Department of Planning
GPO BOX 39
SYDNEY NSW 2001
Attn : Ben Lusher
Metropolitan Projects

MP-2006/257

25 October 2010

A concept plan and major project application for proposed development is located on two sites. The development on the Dwyer's site sits on top of the podium formed by the council-approved mixed retail, commercial, cinema complex development, and comprises of a hotel of 6 floors accommodating 200 rooms, a conference facility, offices and restaurant. The development on the Oxford Tavern site comprises of a relocated tavern and retail at ground floor, two office levels, and a residential building above the podium including 10 floors and up to 60 apartments

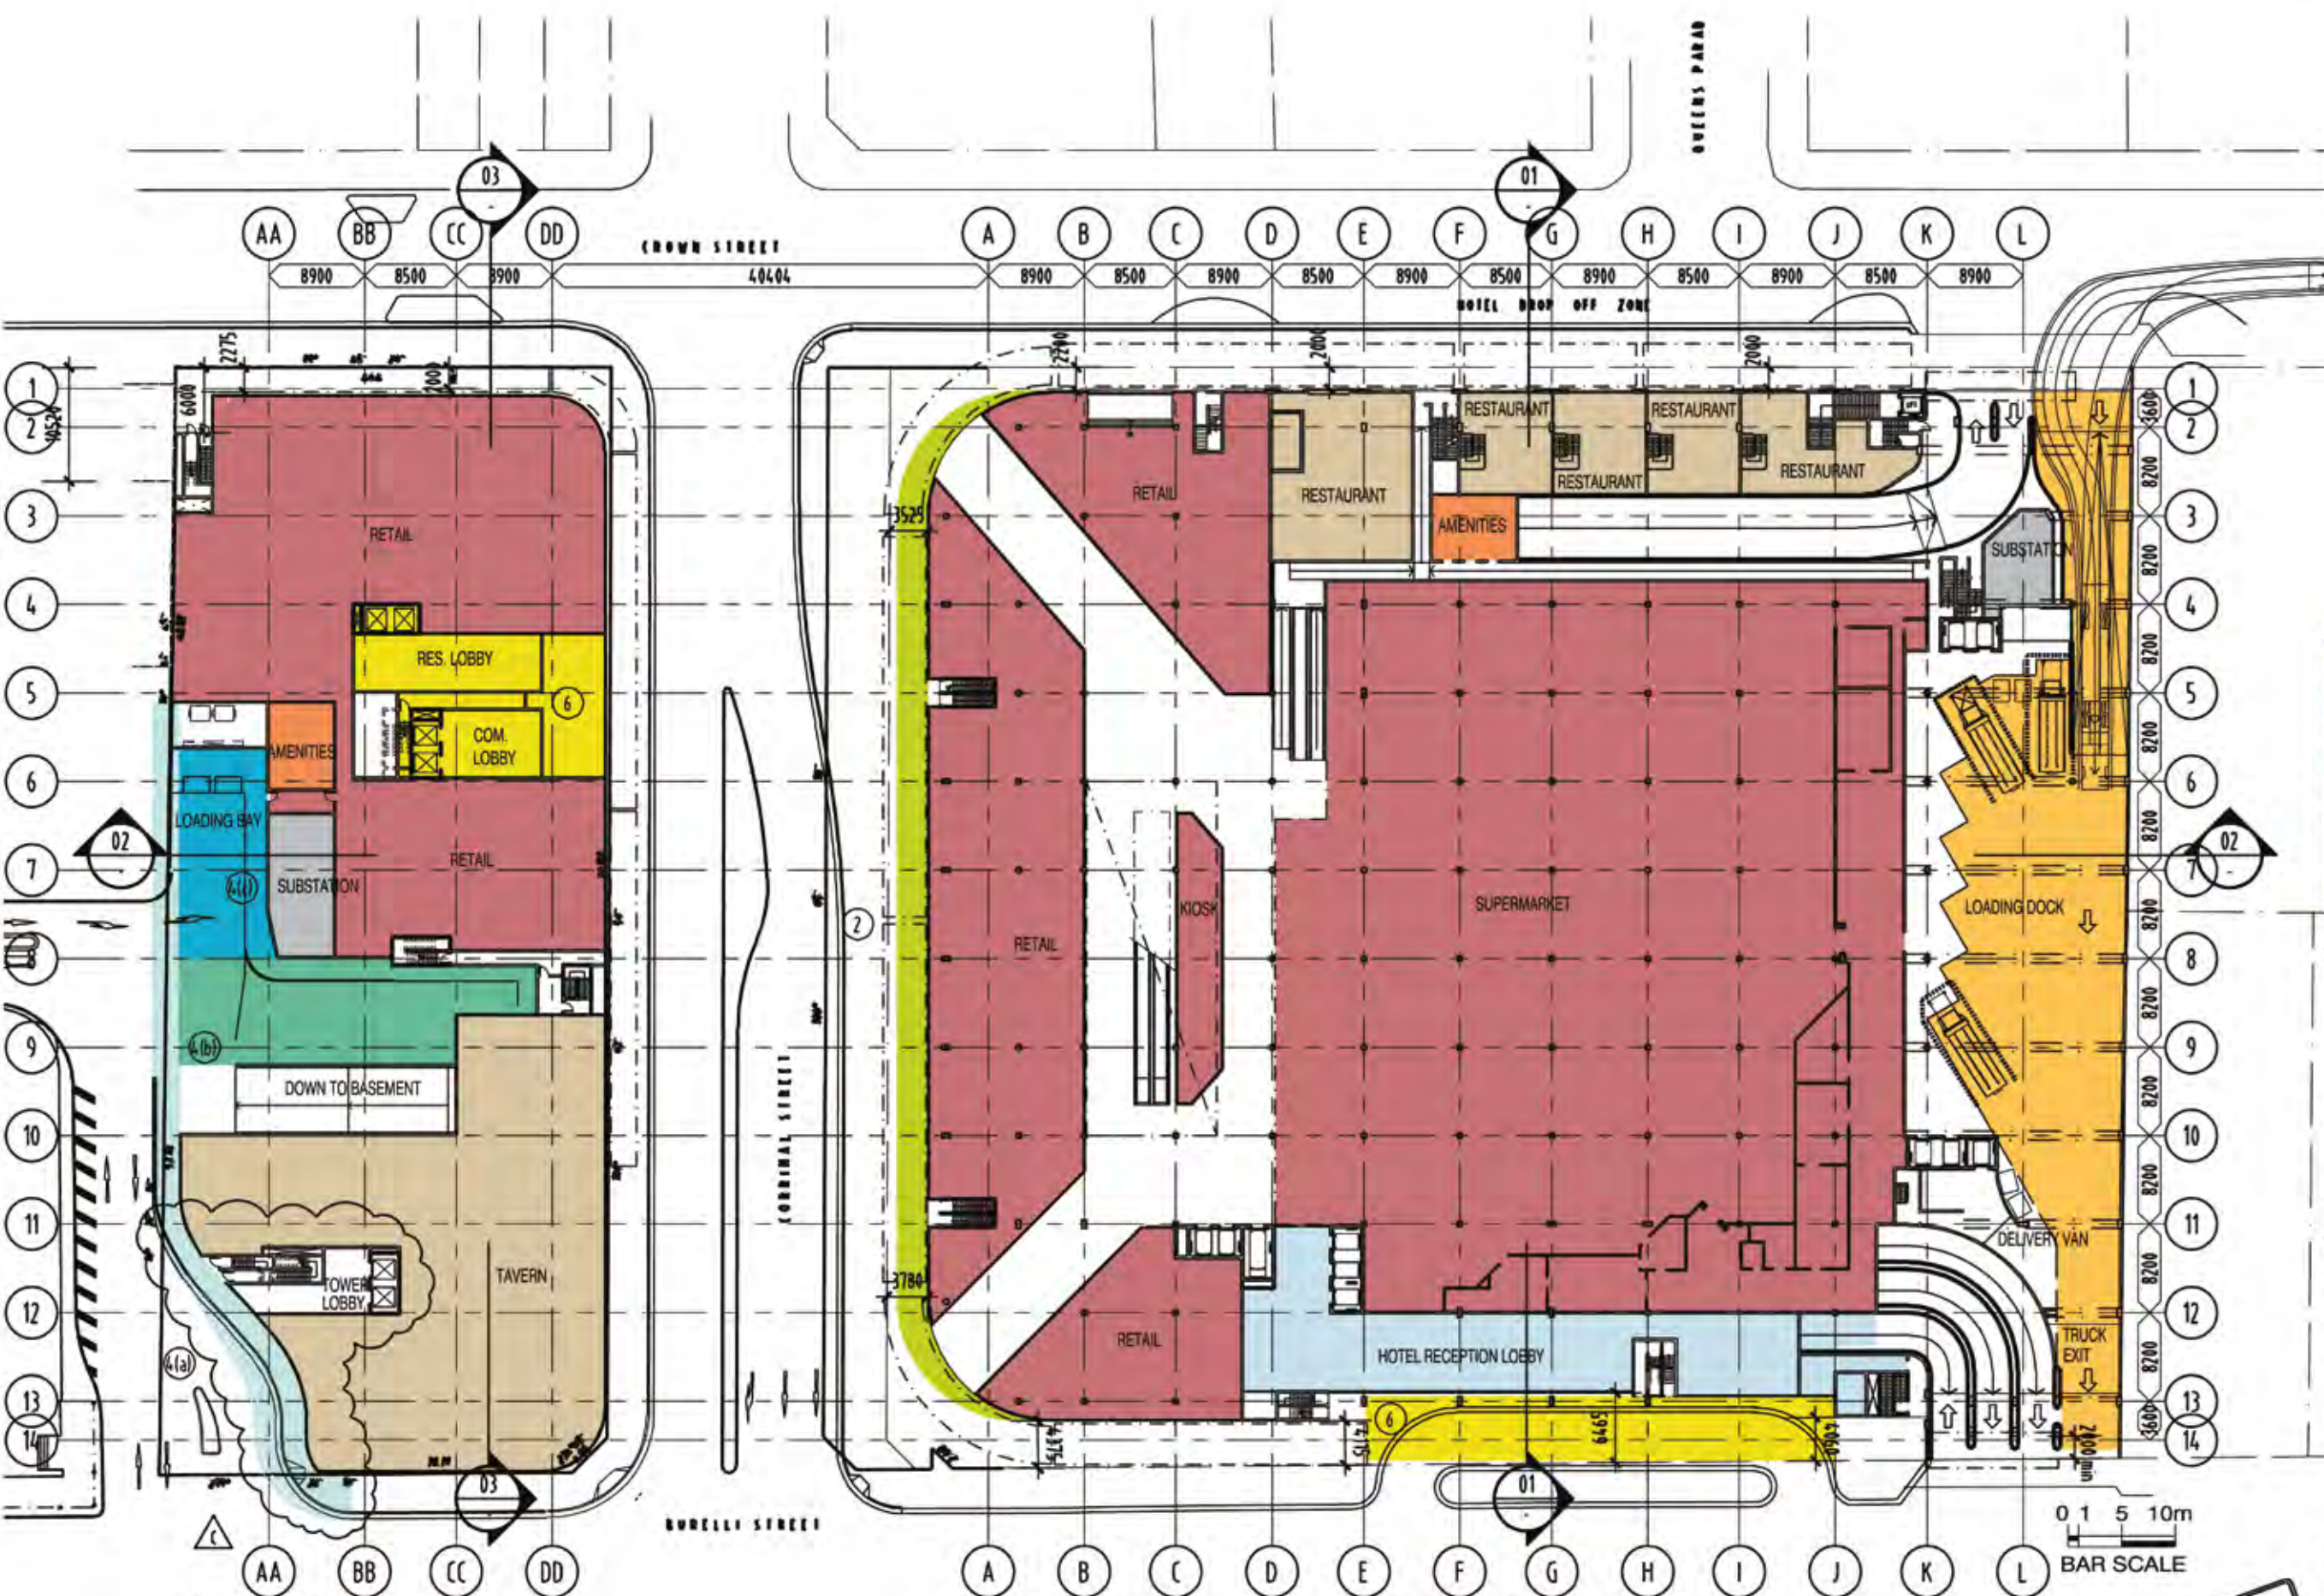
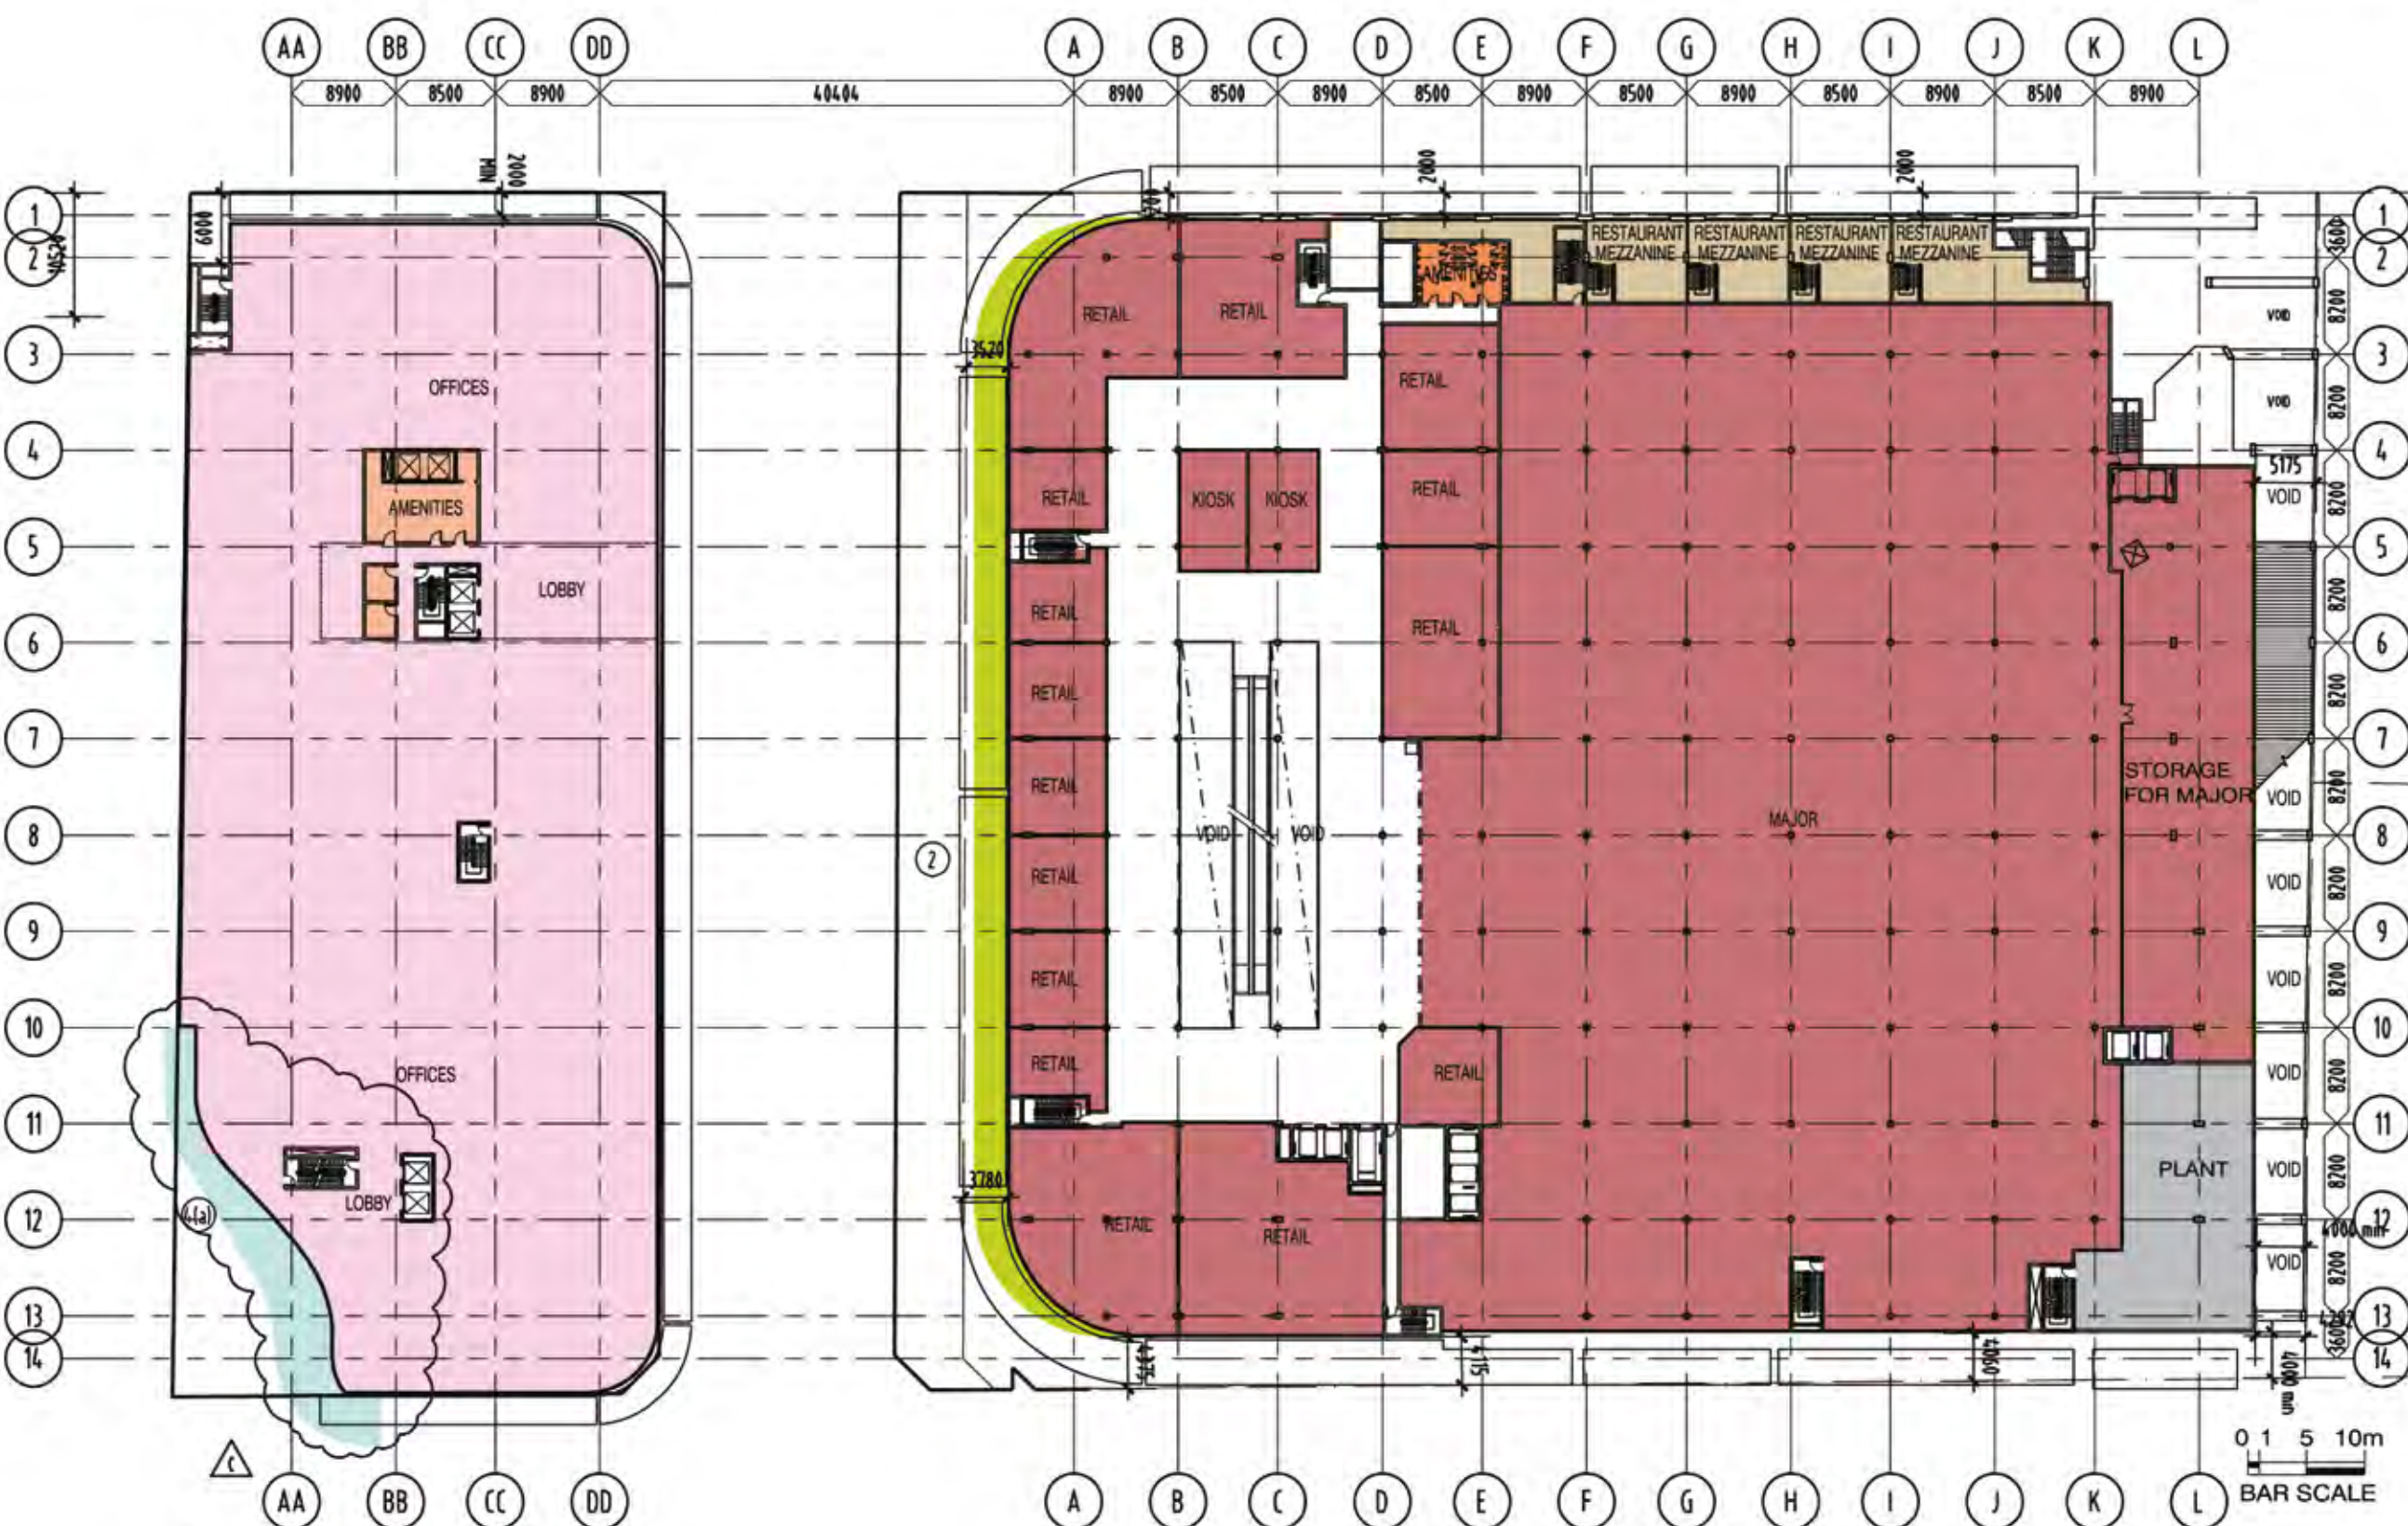
The design of the vehicle entrances and the hotel porte cochere is poor. The pedestrian path is significantly disrupted for more than 70 metres along Burelli Street. This is a significant disruption which is contrary to the Objectives and Controls contained in the DCP. Clause 4.3.2 requires a setback of 1.5 metres from any neighbouring residential property. This has not been demonstrated on these plans.

The proposed 0.9m footpath alongside the Porte Cochere is too narrow. In justifying this width the traffic report refers to the minimum requirements in Austroads (1995, p19). However Austroads also recommends a range of widths necessary to cater for people with limited mobility. It states that where possible, sufficient footpath width should be provided to allow two wheelchairs to pass. This requires a minimum of 1.5m footpath width but a desirable width of 1.8m. Council has a responsibility to provide equal access for people with disabilities.
